Objecting Submission
Ivanhoe Estate, Macquarie Park
SSD 8707

Thank you for the opportunity to comment on this development. We object on the following grounds:

Figure 7 – Shrimptons Creek Indicative Plan

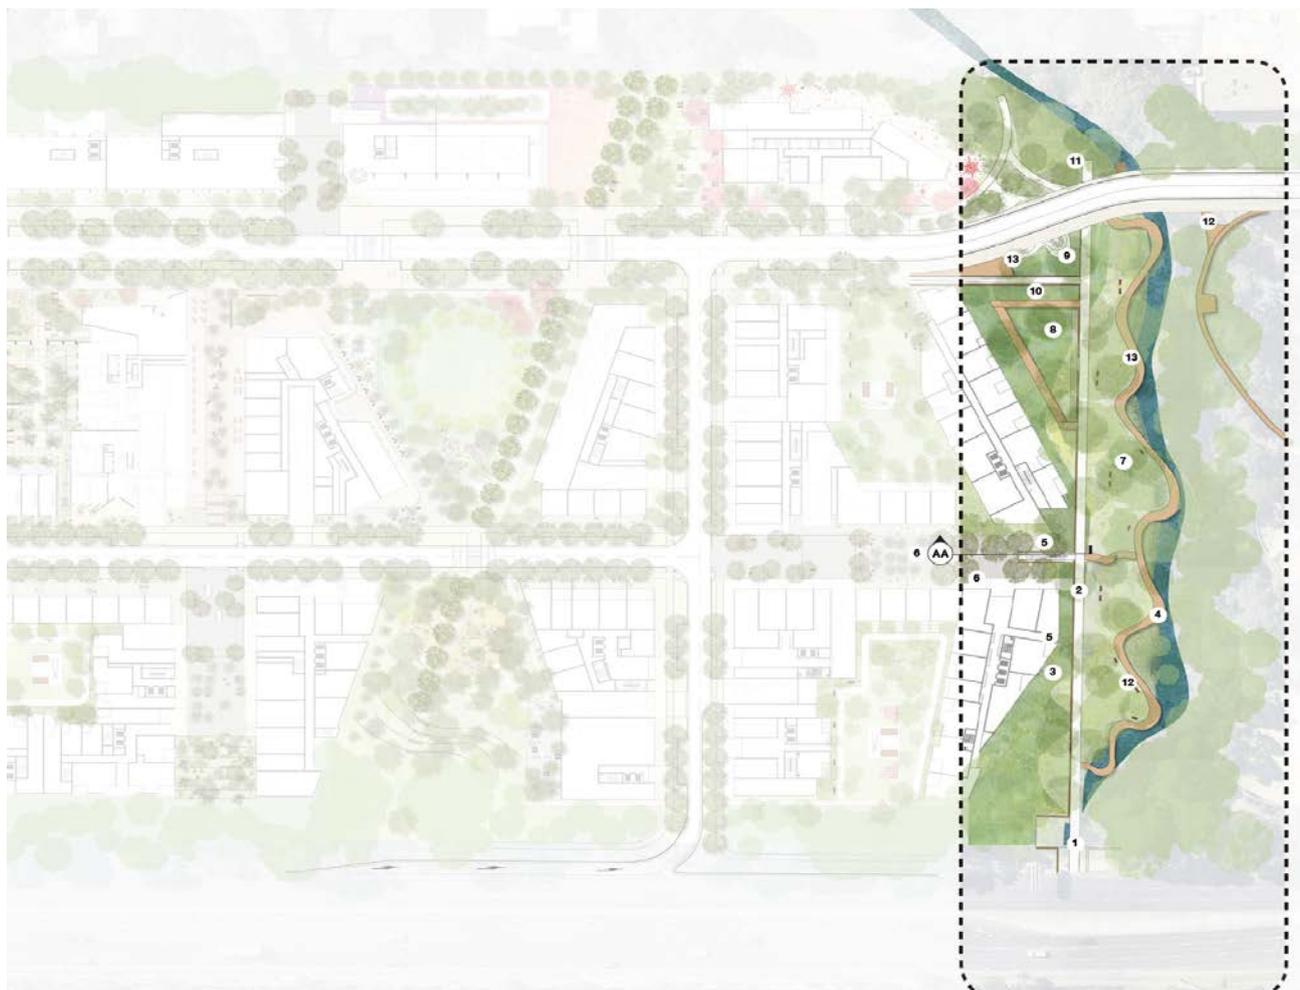
- A buffer to Shrimptons Creek is needed to avoid impacts to the existing vegetation along the creek.
- The proponent may need to refer this concept proposal to the Commonwealth Government as a matter of national environmental significance given the Sydney Turpentine Ironbark Forest (STIF) is a CEEC under the EPBC Act.

- There should be no pathway included within the 20m riparian corridor as it may have negative impacts from runoff and other pollutants. Active recreation may affect water quality, bank stability and conflict with the goal of rehabilitating Shrimptons Creek in the long term.
